Subject: Pemulwuy Mixed Use Development, Redfern (MP06_0101 MOD 1 & MP11_0093)

1. I have reviewed the Pemulwuy Mixed Use Development (MP06_0101 MOD 1 & MP11_0093) and the submitted plans on exhibition at the NSW Department of Planning & Infrastructure, 23 -33 Bridge Street, Sydney.

Proposed Shadow Diagrams March/Sept 21
(Equinox)

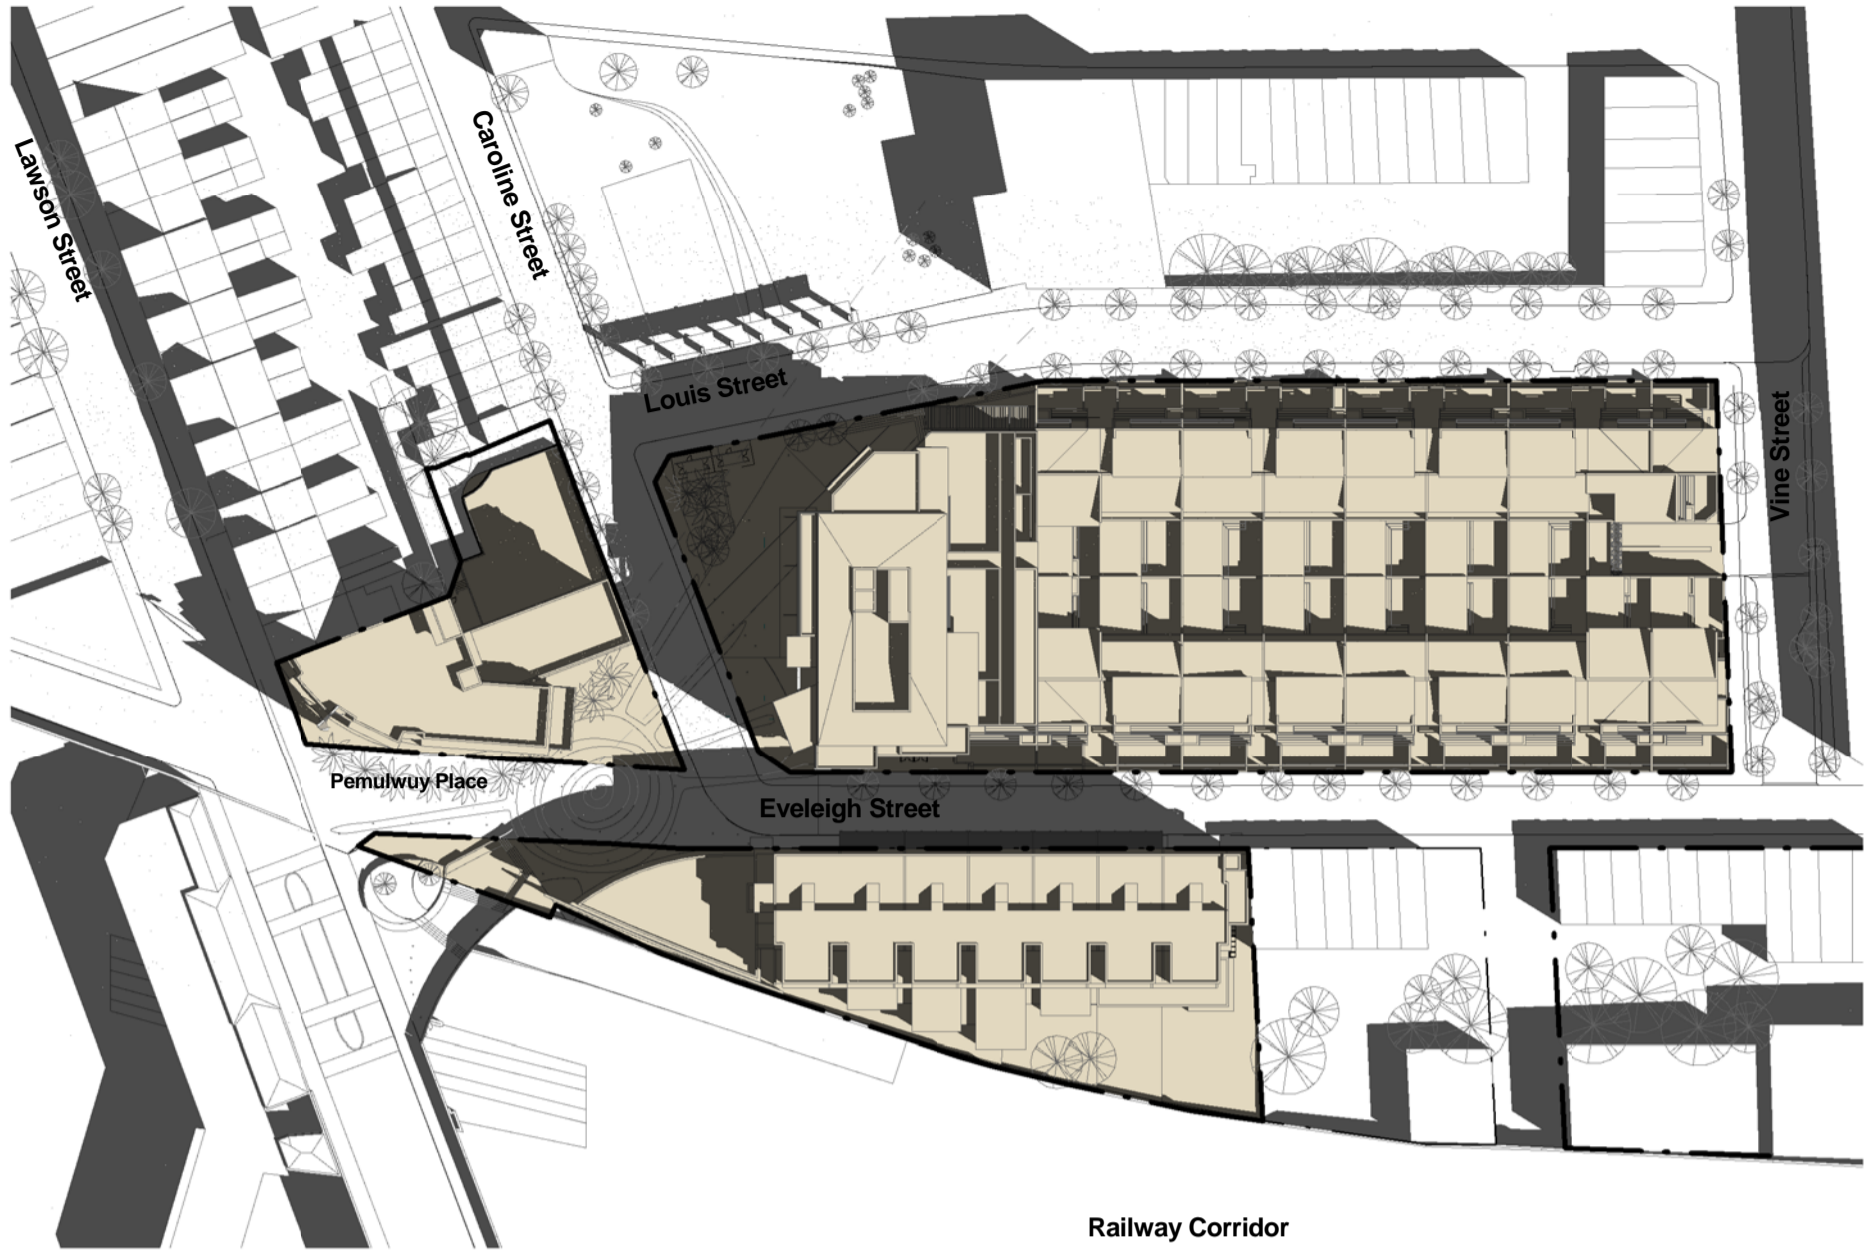
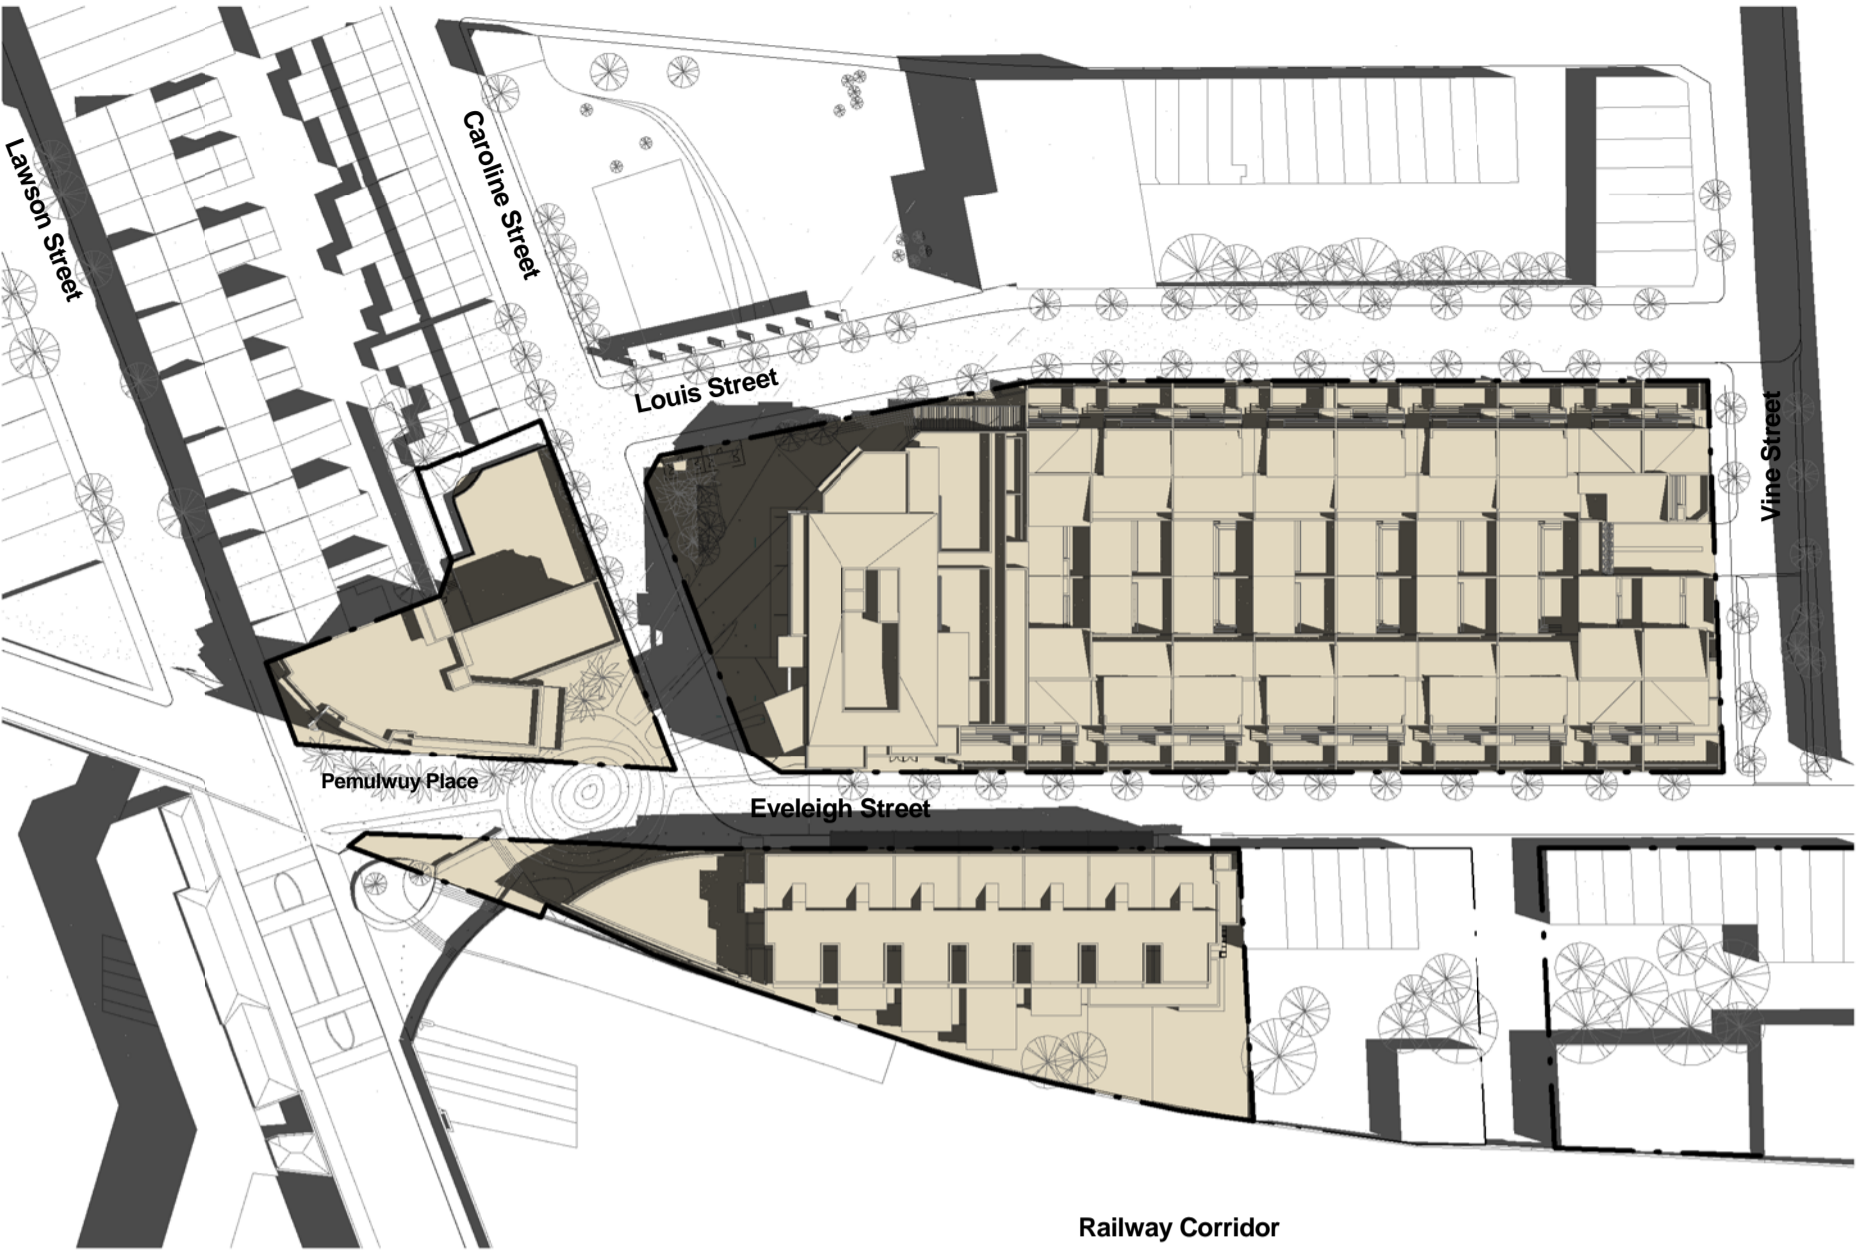
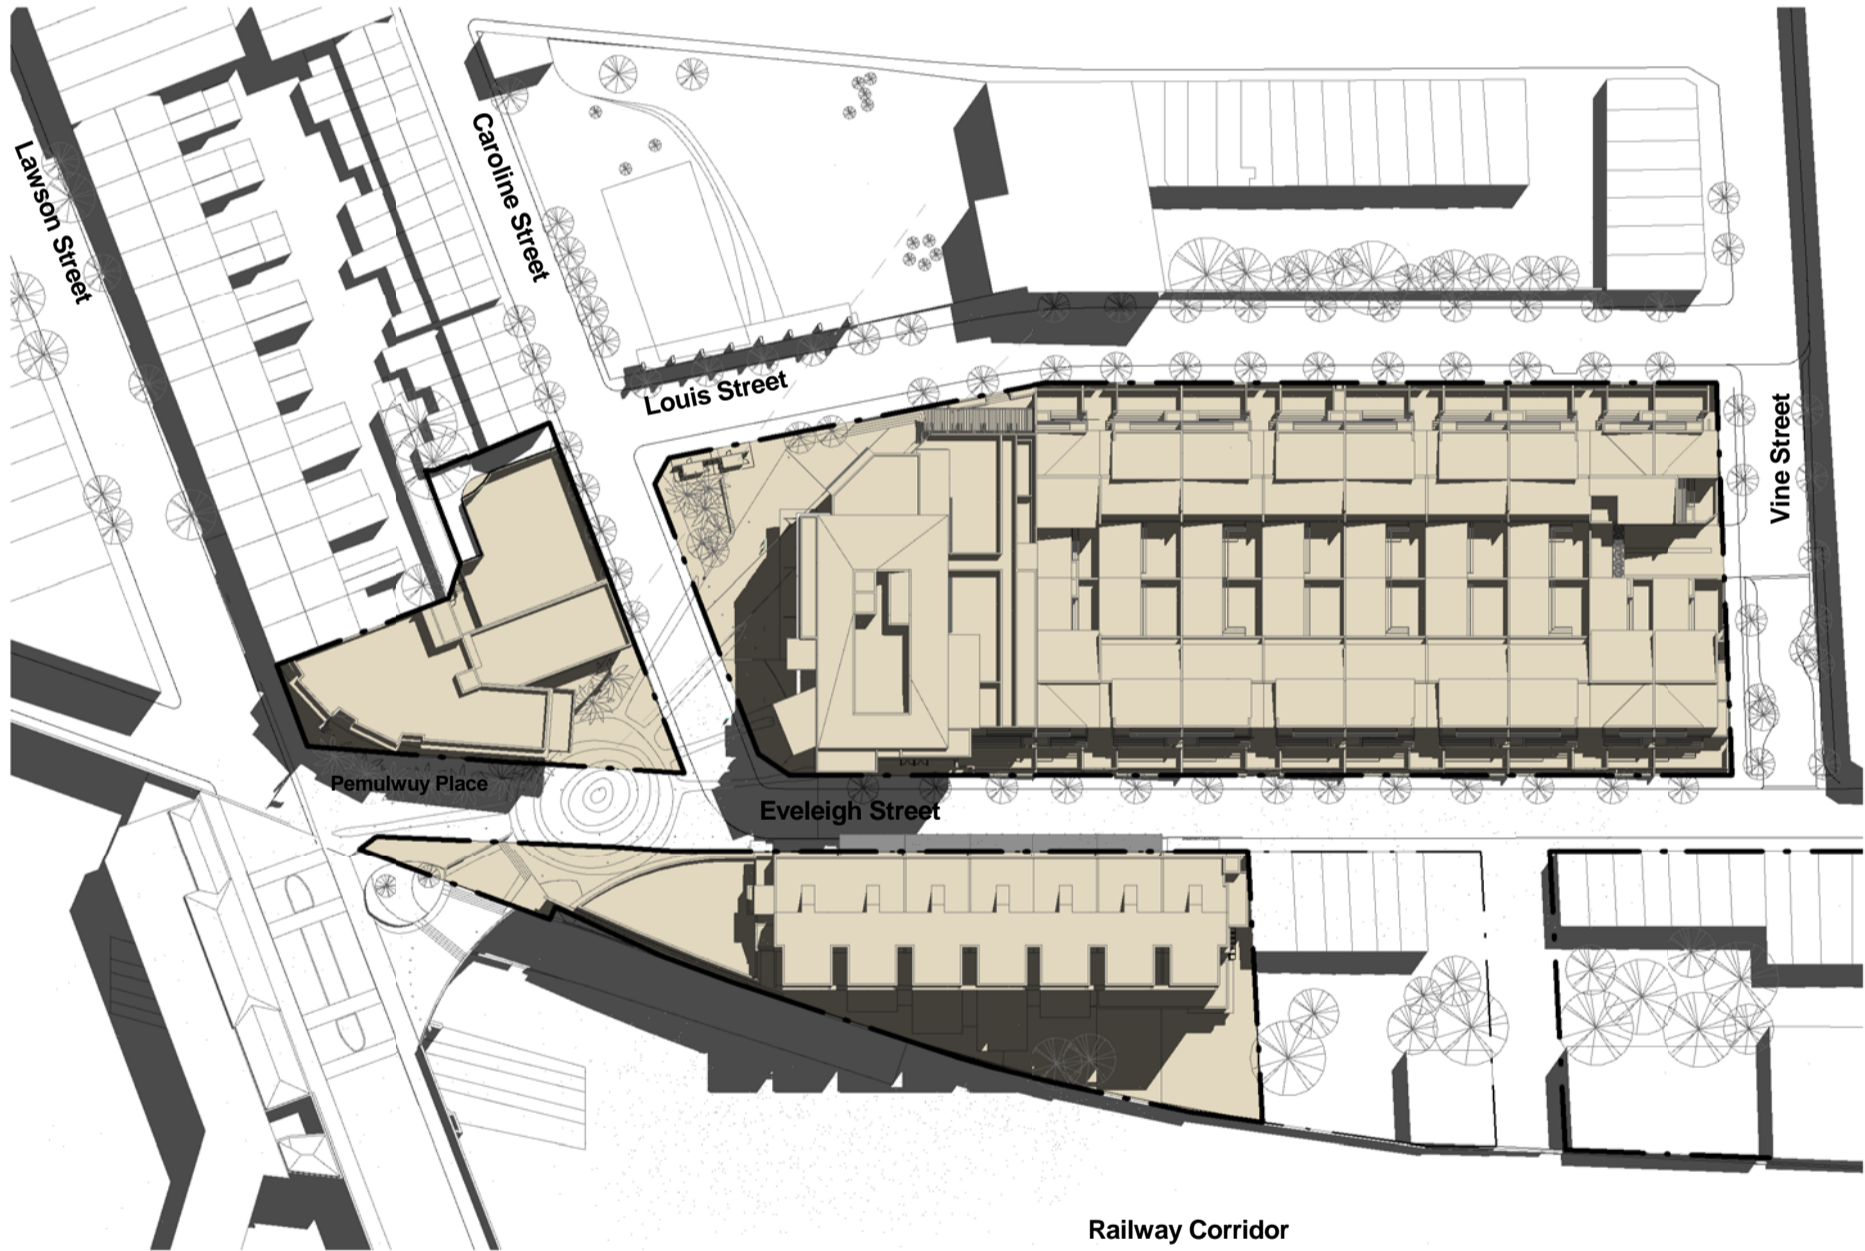
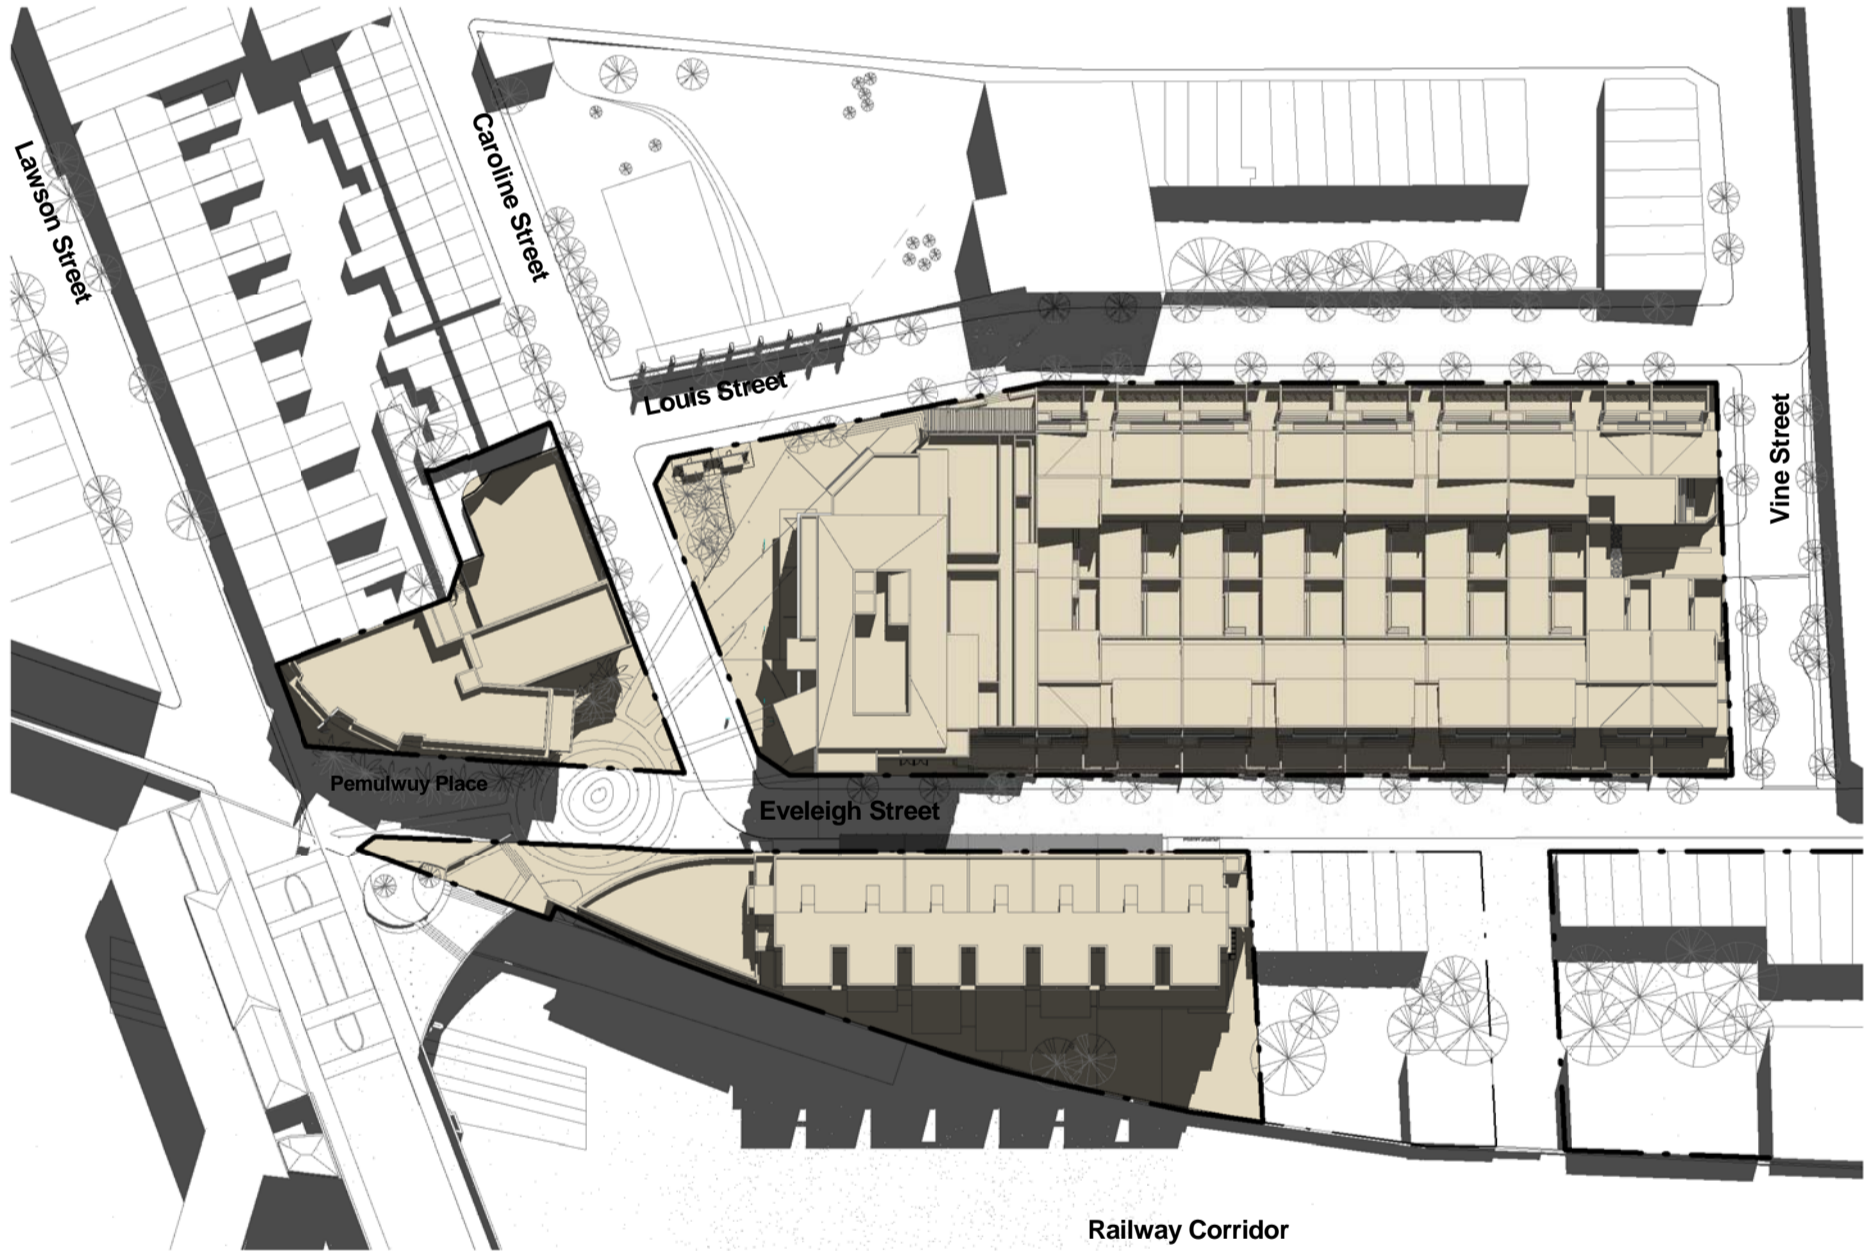
17. The Development contemplates:
 - a. a 6 story student accommodation on Eveleigh Street adjacent to the railway line; and
 - b. a large 6 storey mixed use tower at the top of Louis Street that incorporates a gymnasium.
18. These two buildings cast significant overshadowing of adjacent open space, roads, community areas, private property and even the proposed child care centre.
19. These buildings are significantly oversized for the area and are inconsistent with the zoning set by the Redfern-Waterloo Authority.
20. In my submission, the Redfern-Waterloo Authority zoning should apply with respect to the size and location of large buildings. ie large buildings should be located in the vicinity of Vine Street.

- g. the Development should not be allowed to overshadow public spaces, roadways, community areas and private property; and
- h. the AHC should consider a more modest and less complex development consistent with its level of expertise.
